**CHARLOTTE - MECKLENBURG**  
**PLANNING COMMISSION**

**SUBJECT:** Administrative Approval for Petition No. 99-10 Triven Properties, LLC. Tax parcel 089-161-10.

REZONING PETITION #99-10

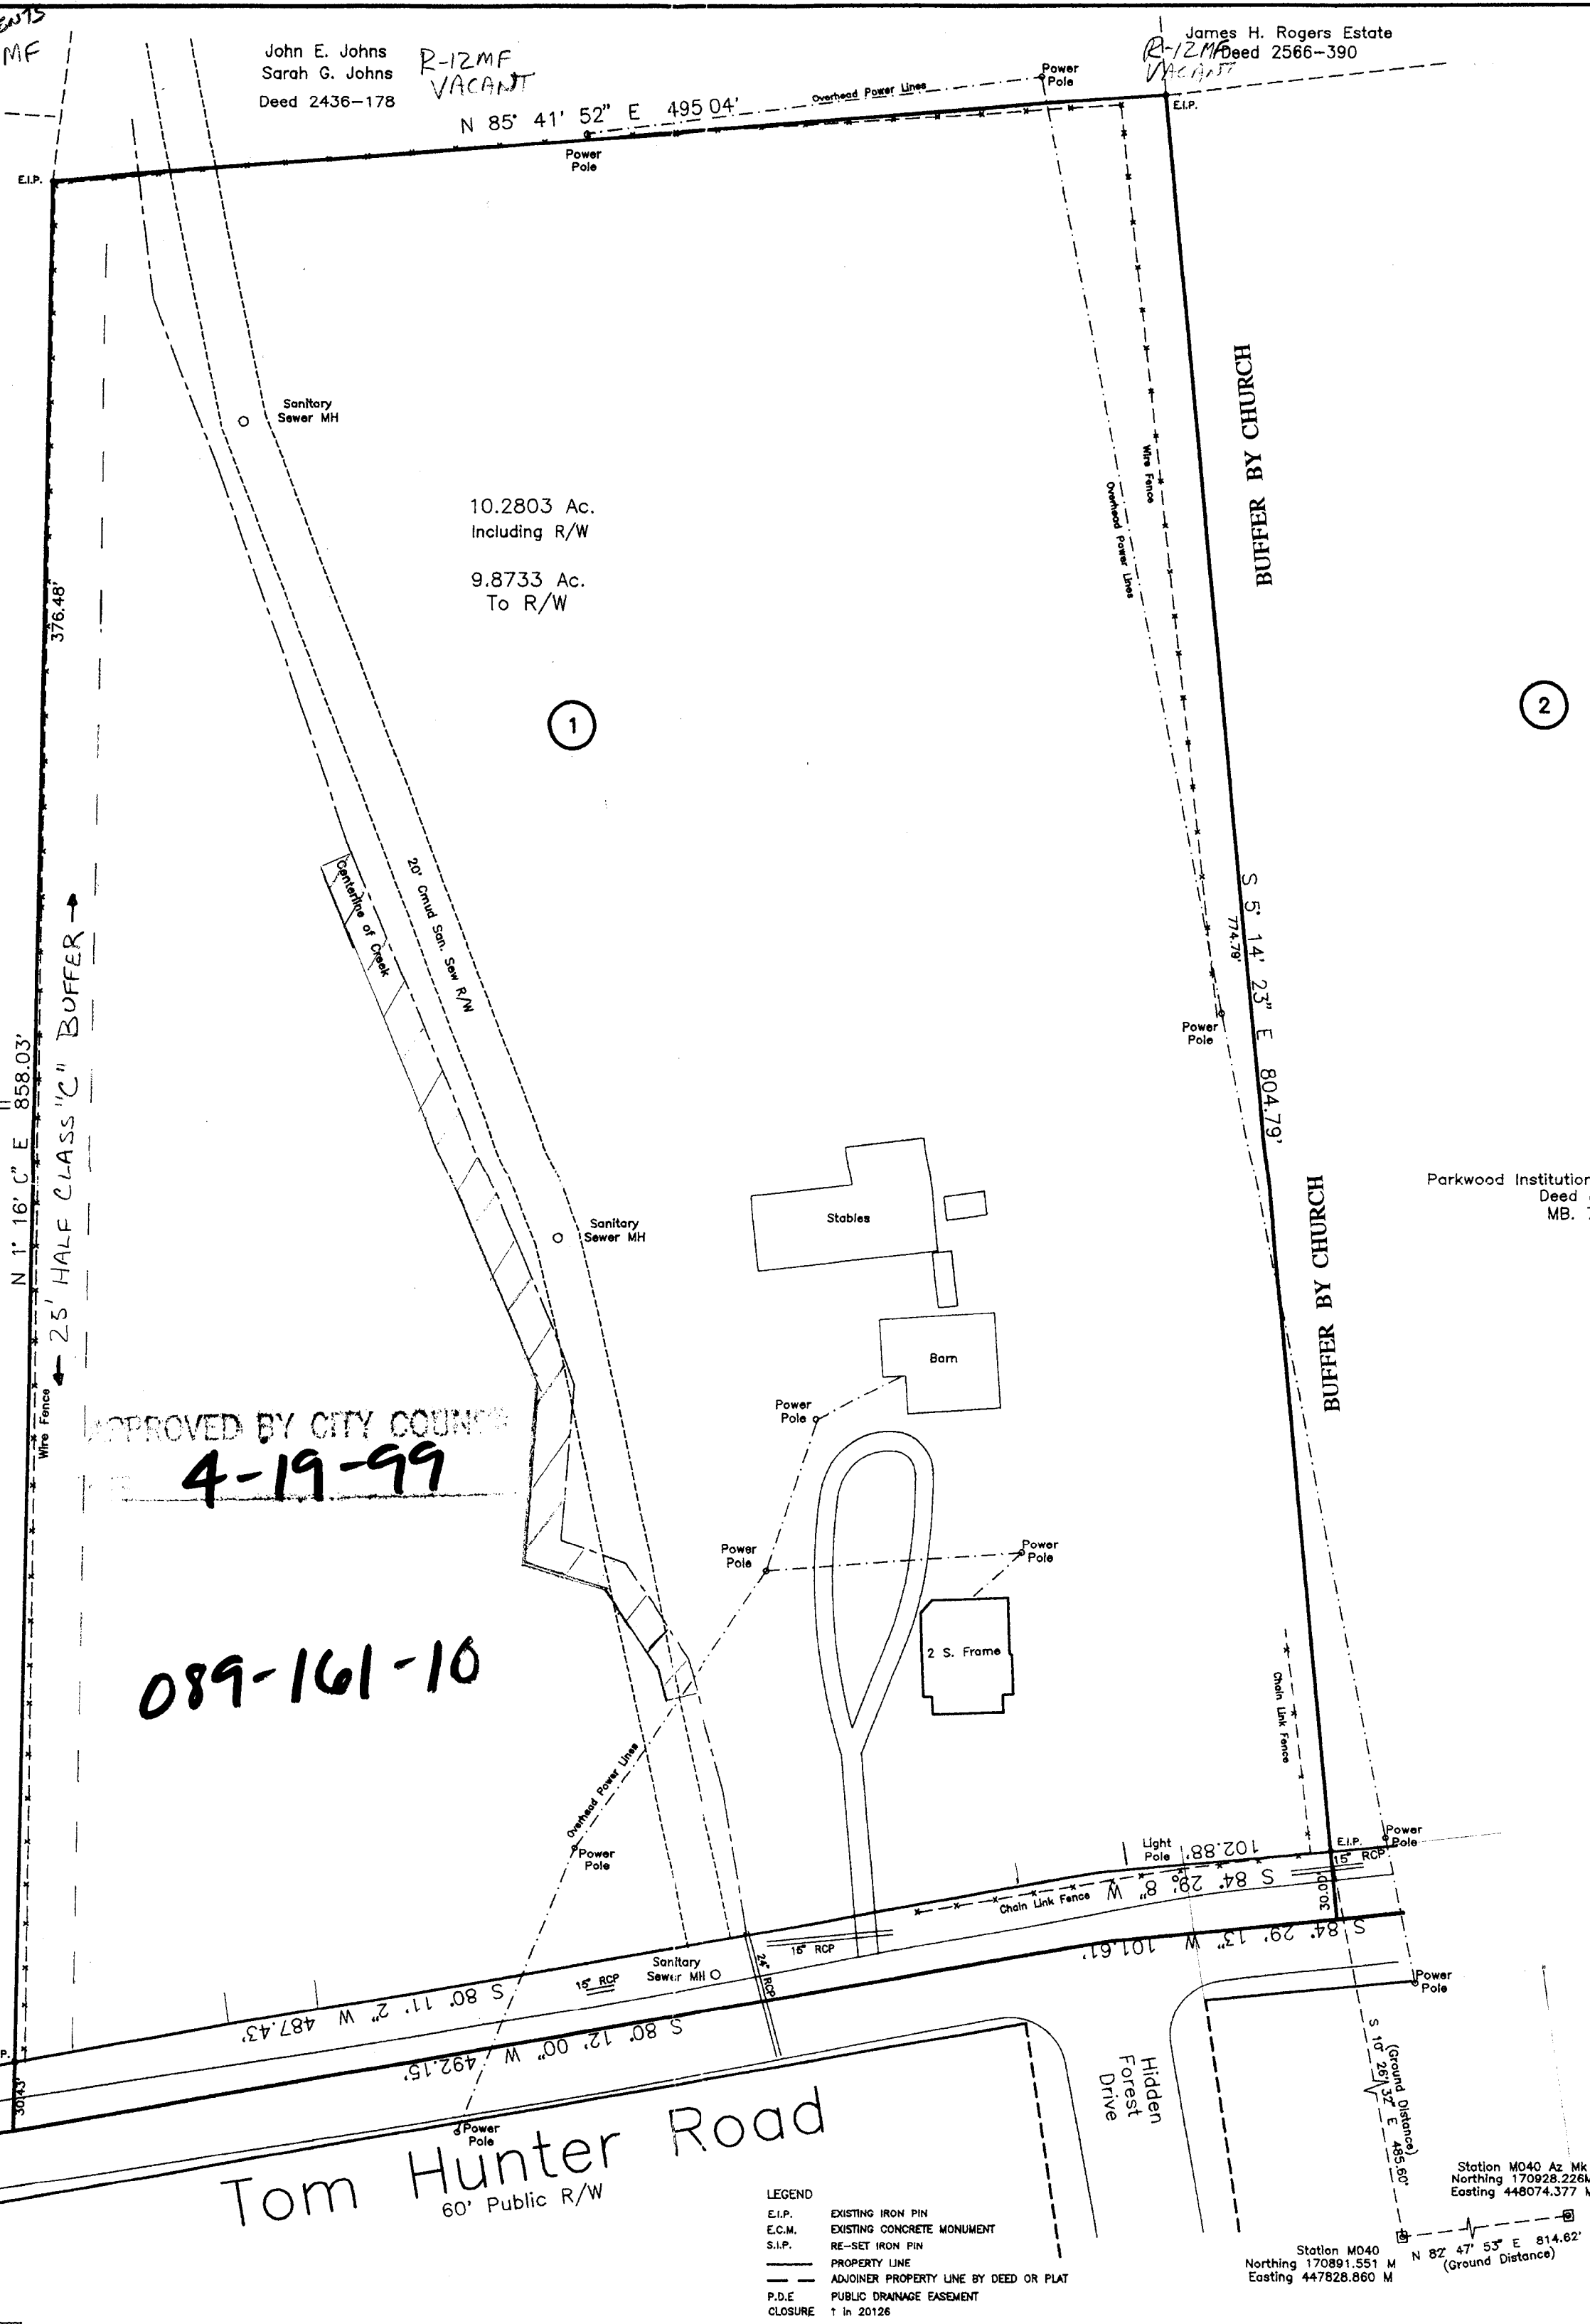
Attached is a copy of the revised plan for the above rezoning petition. The plan has been revised to reflect changes in the sidewalk and planting strip requirements along Tom Hunter Road. Since these changes are minor, I am administratively approving this revised plan. Please use this revised plan when evaluating request for building permits and certificates of occupancy.
